United Church

Planning Consultation Response - Design Amendment

June 2026

title:
**Proposed Elevations C & D
(United Church)**

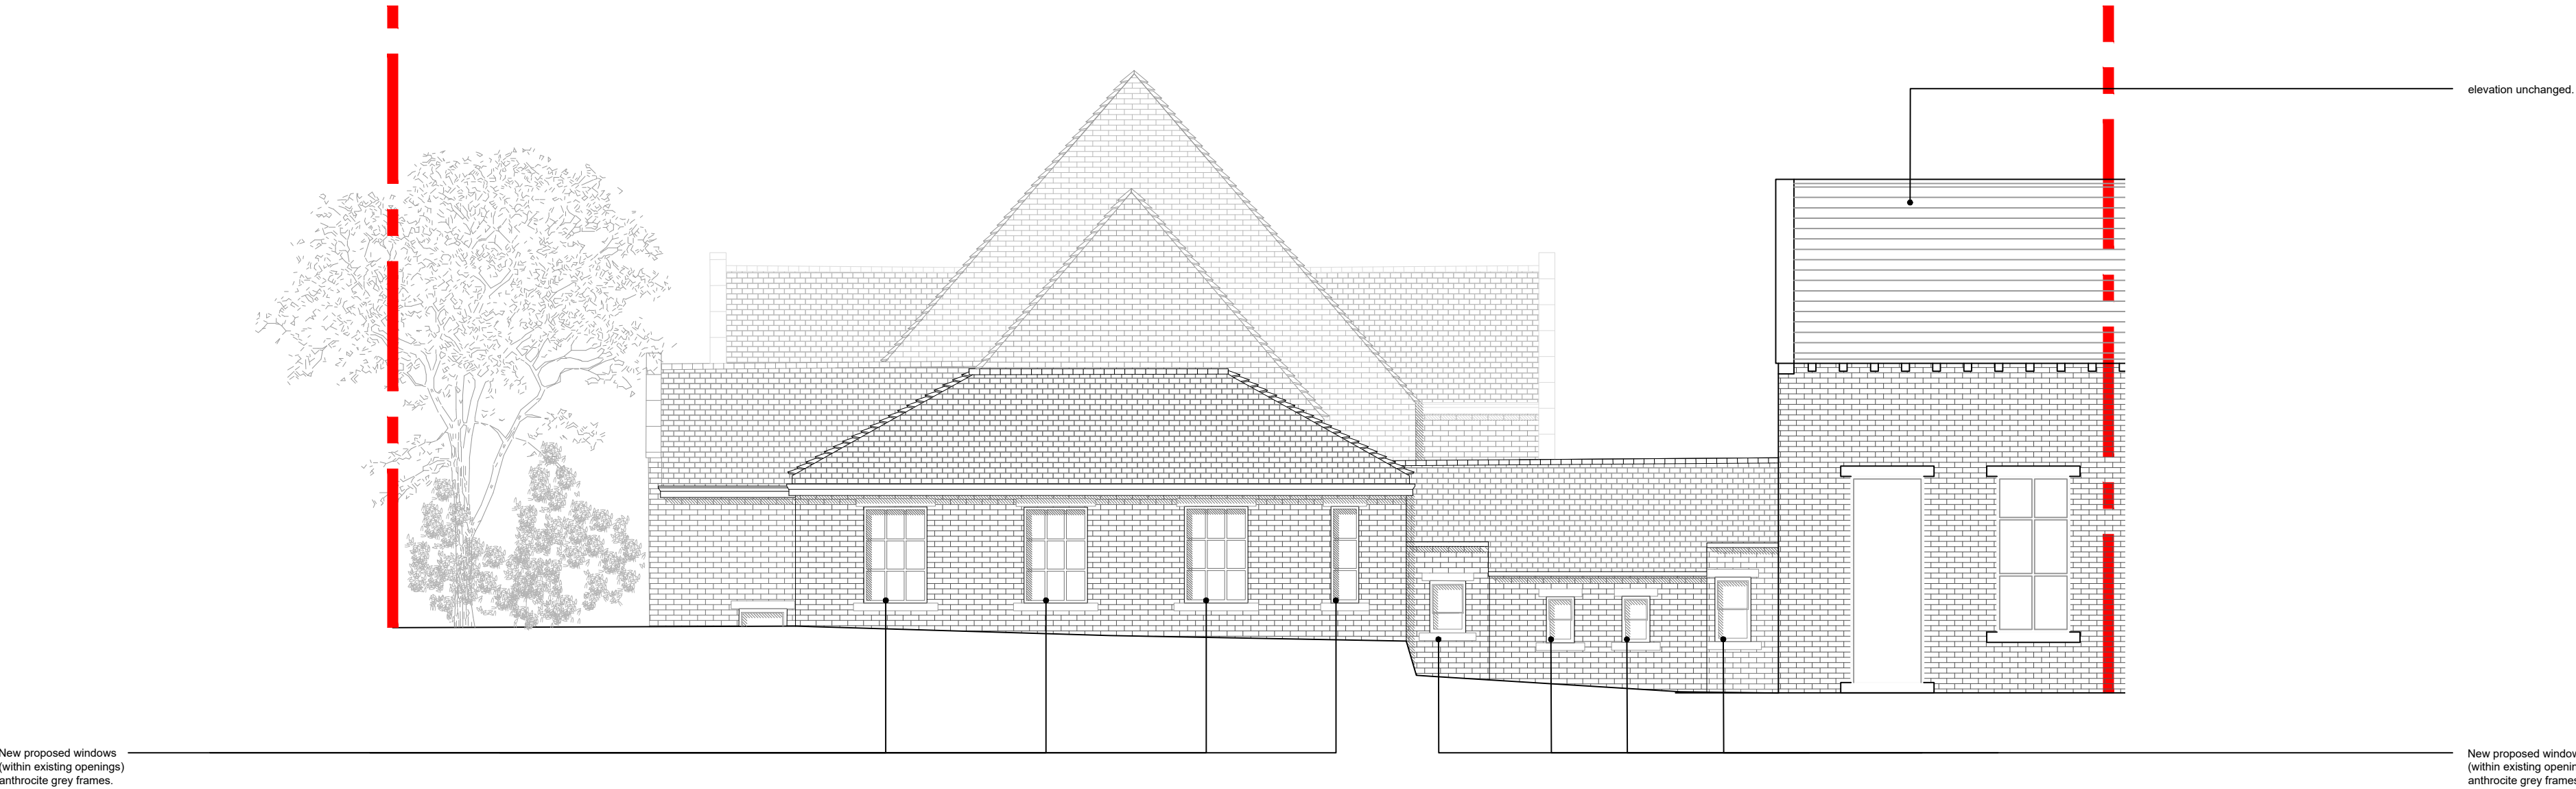
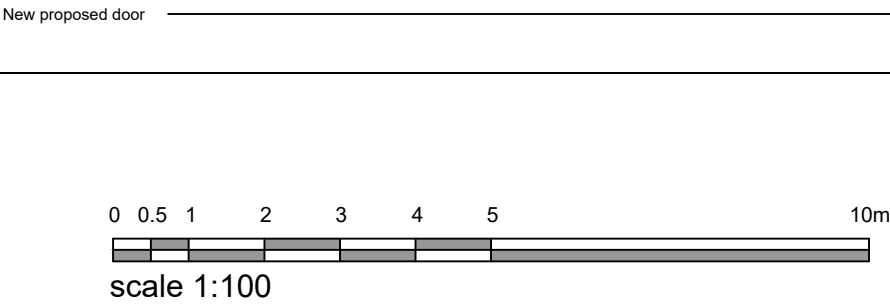
The Conservation Officer raised concerns regarding the relationship between the proposed new entrance door and the adjacent historic arched window on Elevation D.

To improve the visual separation between the existing architectural features and the proposed intervention, the new door opening has been repositioned by approximately 150mm. This amendment increases the amount of retained masonry between the new and existing openings and reduces the visual impact of the proposal on the historic elevation.

In response, the rooflights on Elevations B and D have been reduced in width from 2.5m to 2.0m. The rooflights have also been repositioned and centralised with the gable feature and principal arched window below to improve the overall symmetry and composition of the elevation.
